Reference Planning Application 2024/62/90339/E

With reference to the above planning application submitted by the owners of the property 19 Cheviot Way, please consider my absolute objection to this proposed development.

PROPOSED BLOCK PLAN
1:500

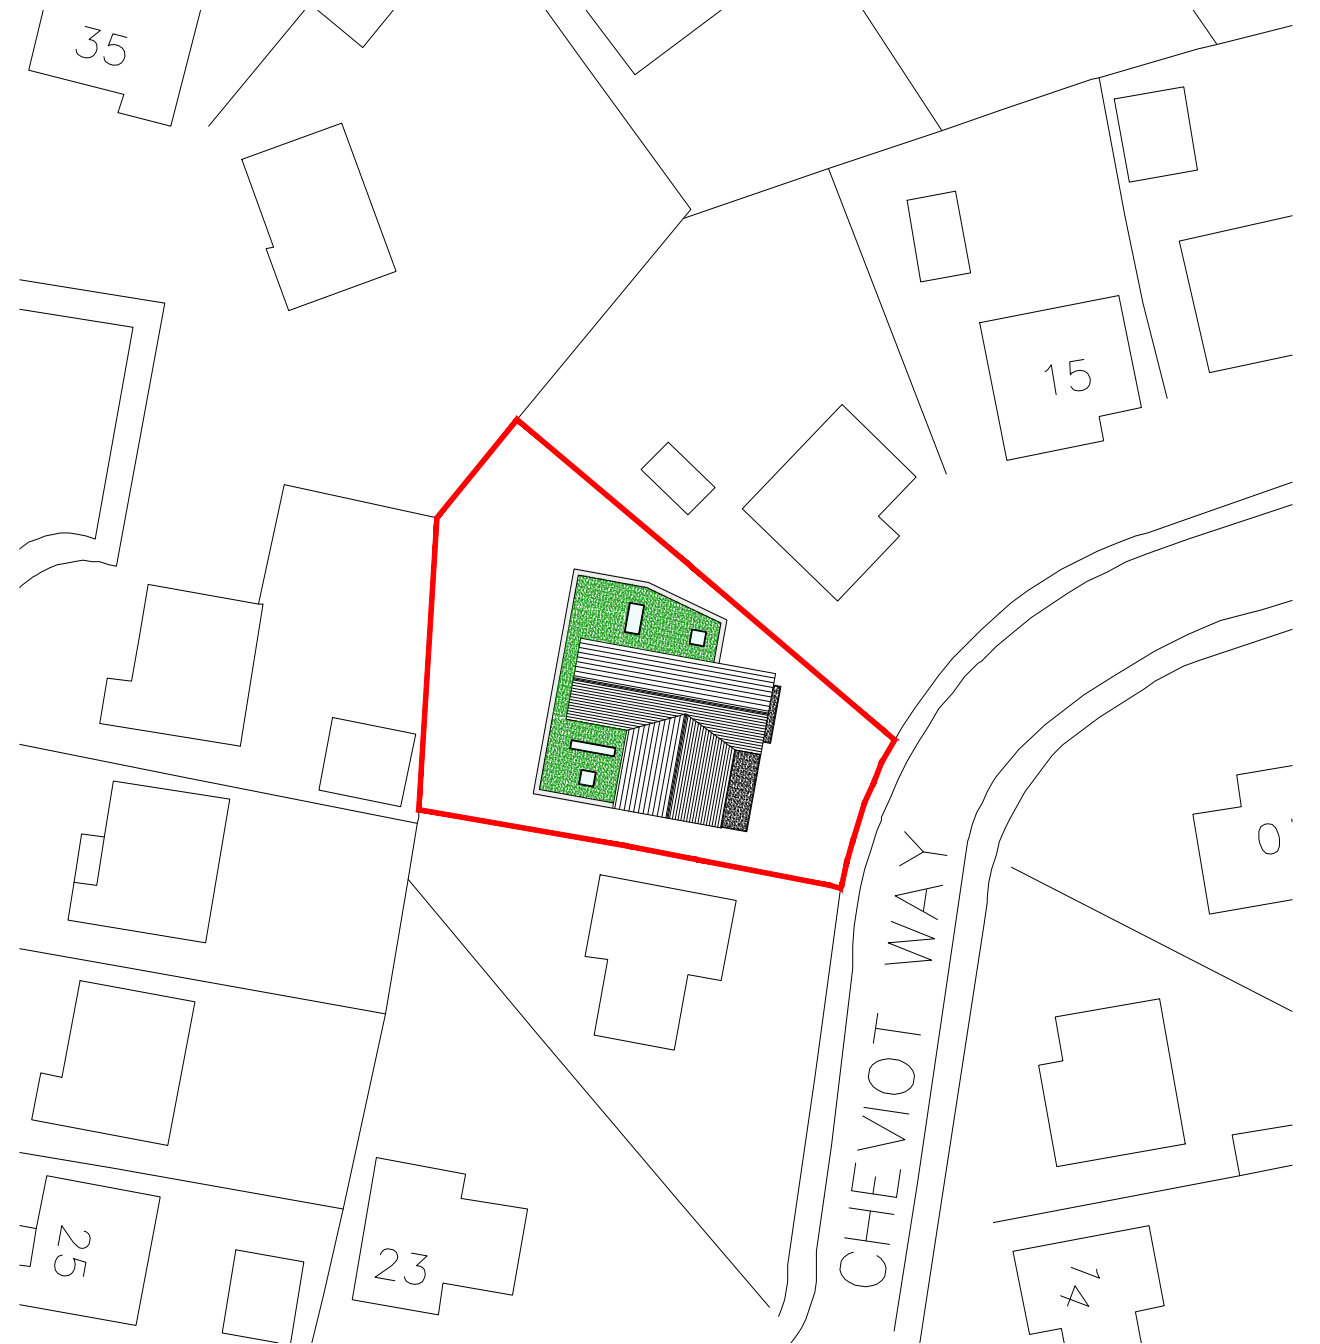
My property is behind and adjacent to the said property and as a consequence of this will affect what I enjoy as complete privacy of my back garden, indeed this elevated terrace will enable those to see directly into my garden in particular my gazebo and hot tub area.

I have no objection to the ground floor extension but it is unacceptable to have a rear and side roof terrace that compromises not only mine but the privacy of others. A major concern would be that this elevated outdoor space would be used as a social space creating noise and overlooking.
